Subject: 107 Felpham Way, FP/258/19

Drawing Title	Site Overview
---------------	---------------

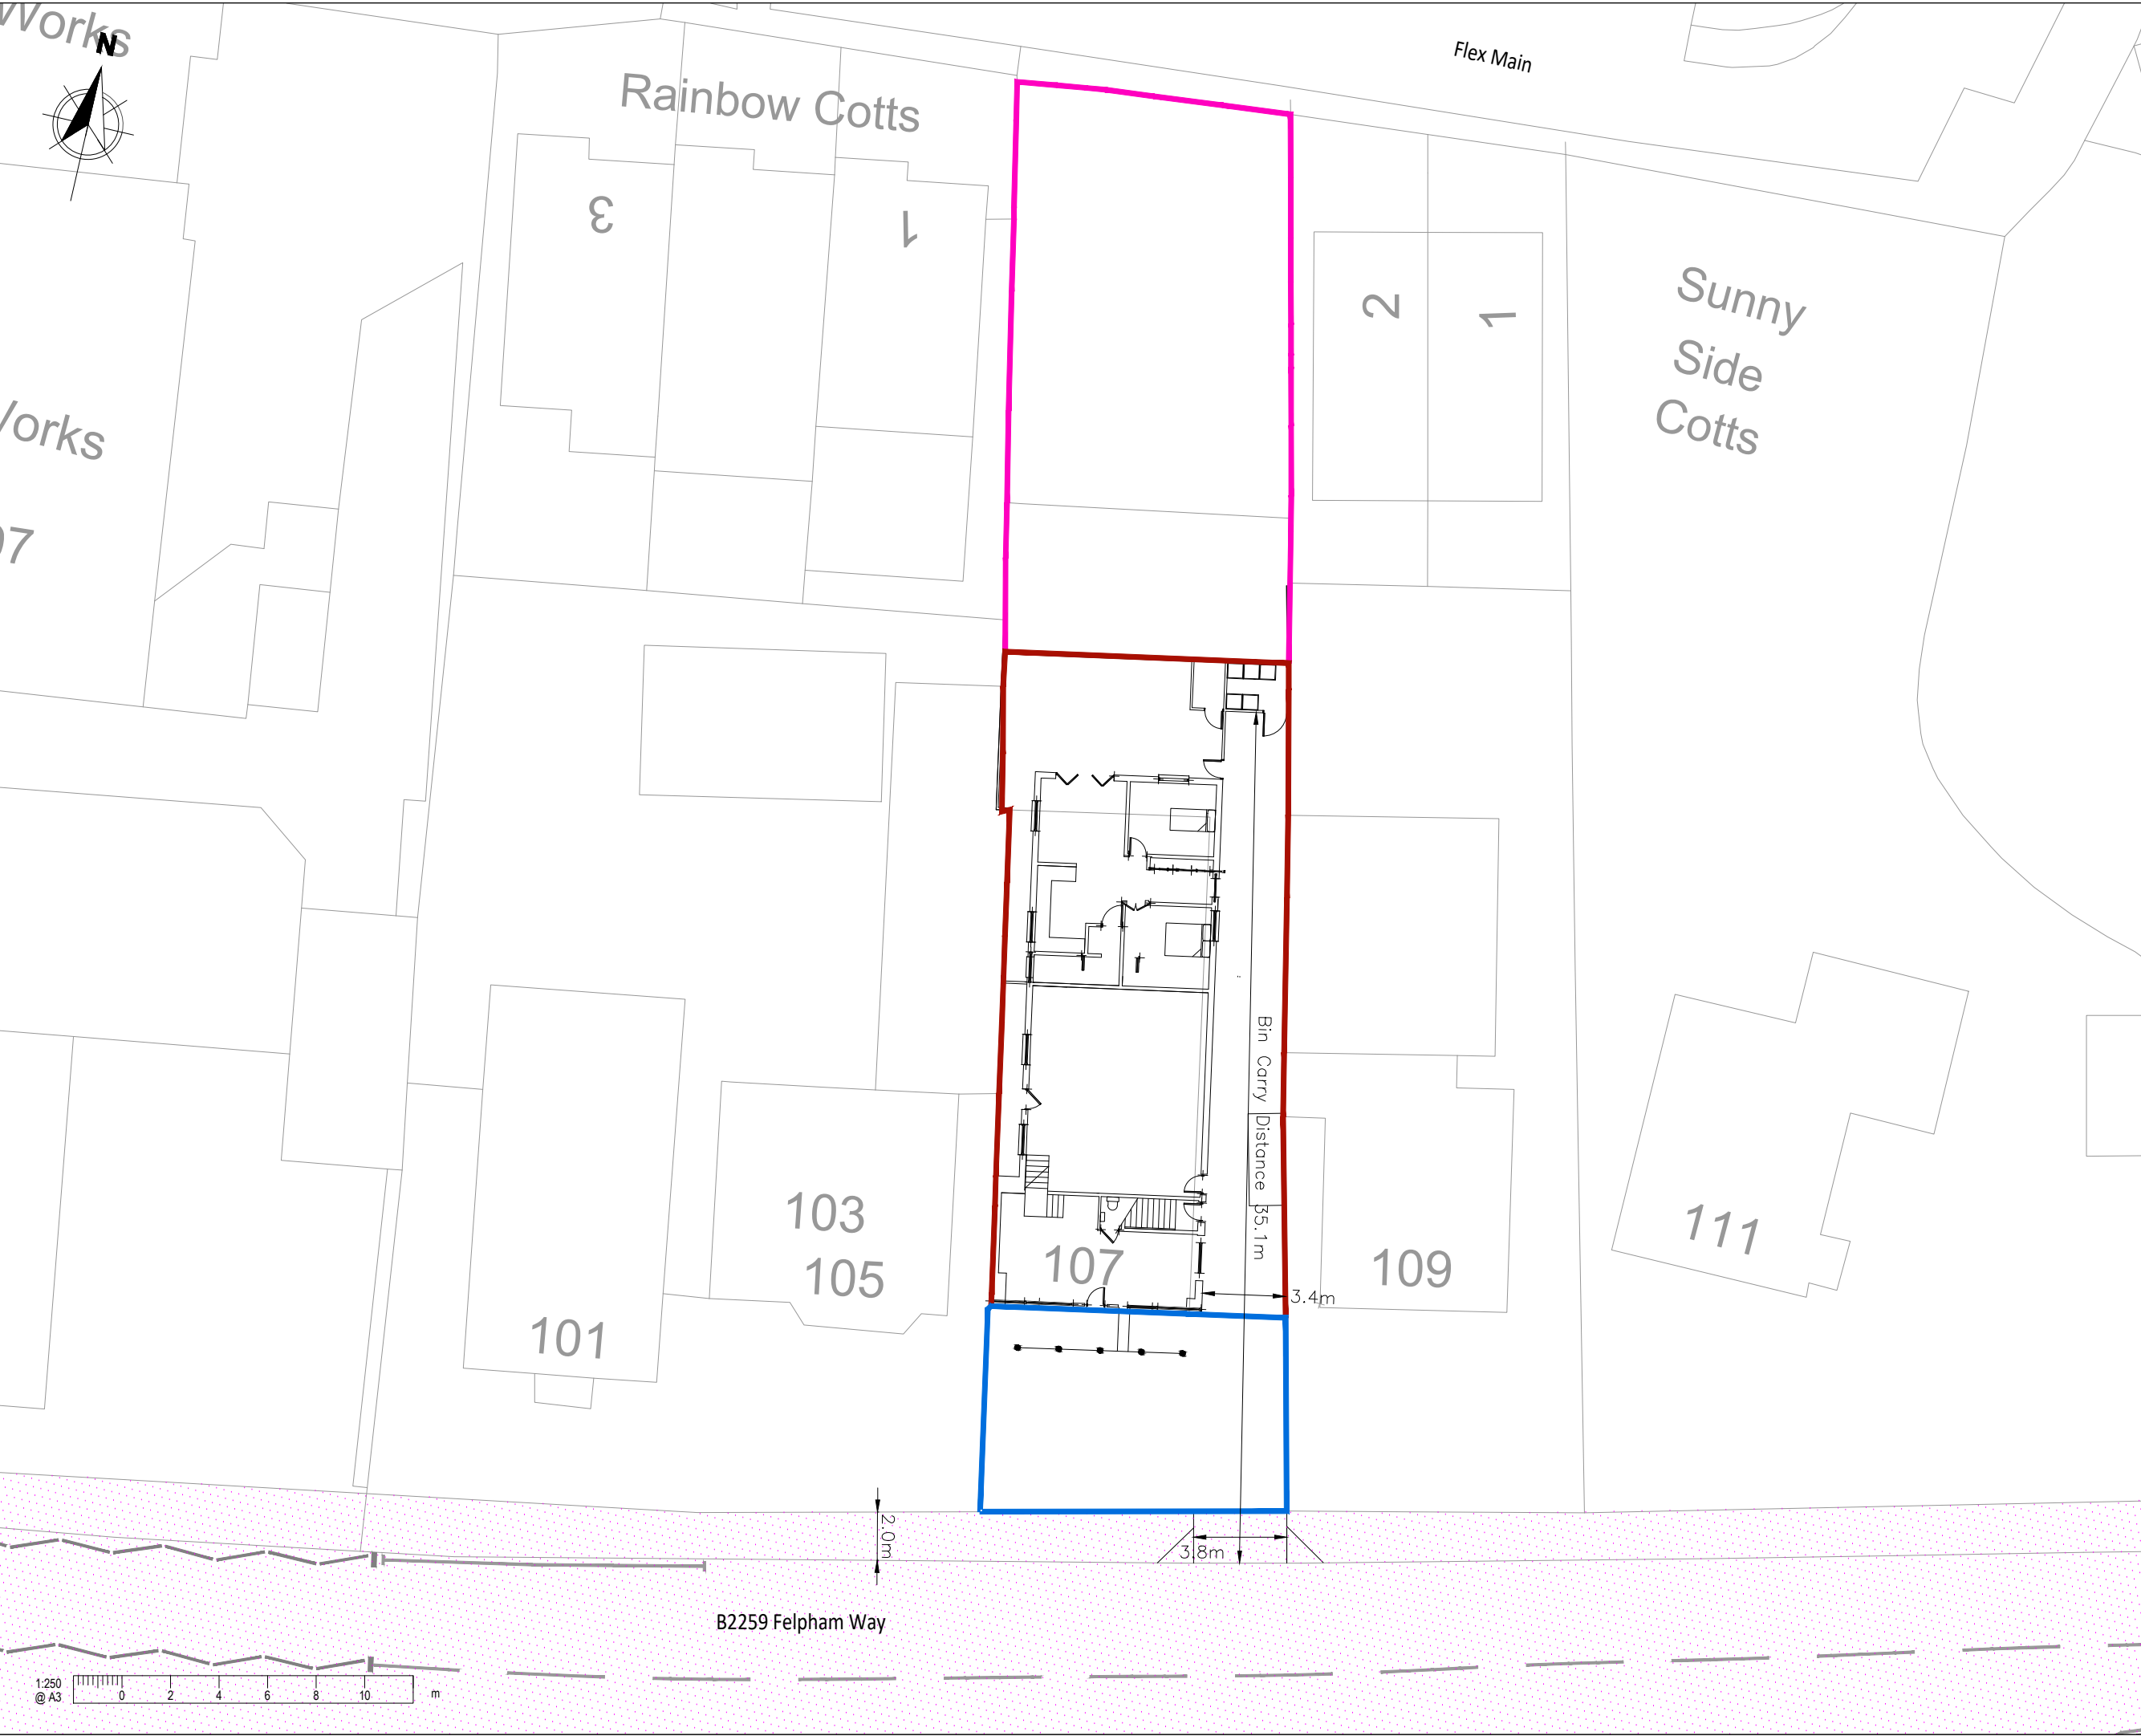
I have gained some advice from our Valuations and Estates Management team regards the forecourt. As this land is owned by WSCC they would not have a legal right to park here. WSCC have not been sent the notice as owner that planning application is proposed on this land. If the application were approved with parking shown here, they would not be able to use the land for private parking without acquiring rights to do so and could therefore be in breach of planning approval
